**EL PASO COUNTY PLANNING AND
 COMMUNITY DEVELOPMENT
 DEPARTMENT**

STORMWATER MANAGEMENT PLAN CHECKLIST

Revised: July 2019

- E** EROSION CONTROL  
NTS
- PREPARE SOIL BEFORE INSTALLING ROLLED EROSION CONTROL PRODUCTS (RECP'S), INCLUDING ANY NECESSARY APPLICATION OF LIME, FERTILIZER, AND SEED.  
NOTE: WHEN USING CELL-O-SEED DO NOT SEED PREPARED AREA. CELL-O-SEED MUST BE INSTALLED WITH PAPER SIDE DOWN.

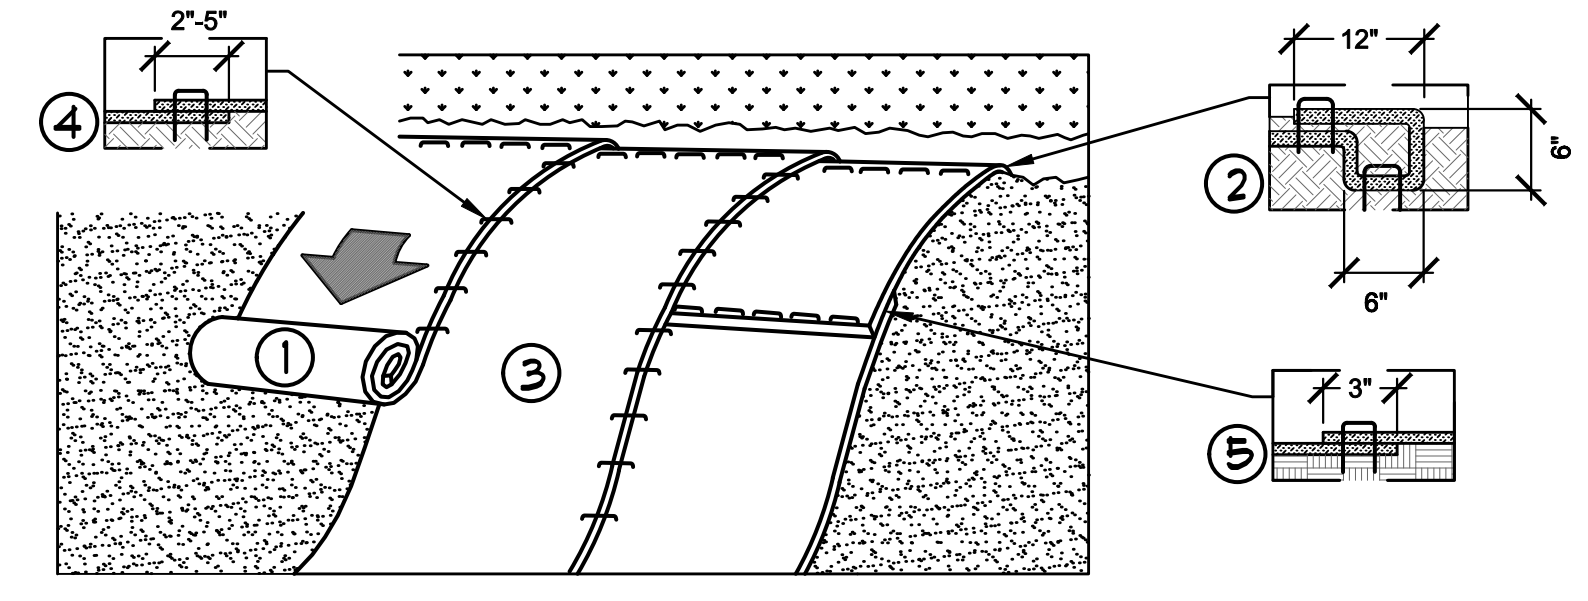
20	Technical drawing details for all control measure installation and maintenance; custom or other jurisdiction's details used must meet or exceed EPC standards	X	X
21	Procedure describing how the SWMP is to be revised	X	✓
22	Description of Final Stabilization and Long-term Stormwater Quality (describe nonstructural and structural measures to control SW pollutants after construction operations have been completed, including detention, water quality control measure etc.)	X	X
23	Specification that final vegetative cover density is to be 70% of pre-disturbed levels	X	✓
24	Outline of permit holder inspection procedures to install, maintain, and effectively operate control measures to manage erosion and sediment	X	✓
25	Record keeping procedures identified to include signature on inspection logs and location of SWMP records on-site	X	✓
26	If this project relies on control measures owned or operated by another entity, a documented agreement must be included in the SWMP that identifies location, installation and design specifications, and maintenance requirements and responsibility of the control measure(s).	X	✓
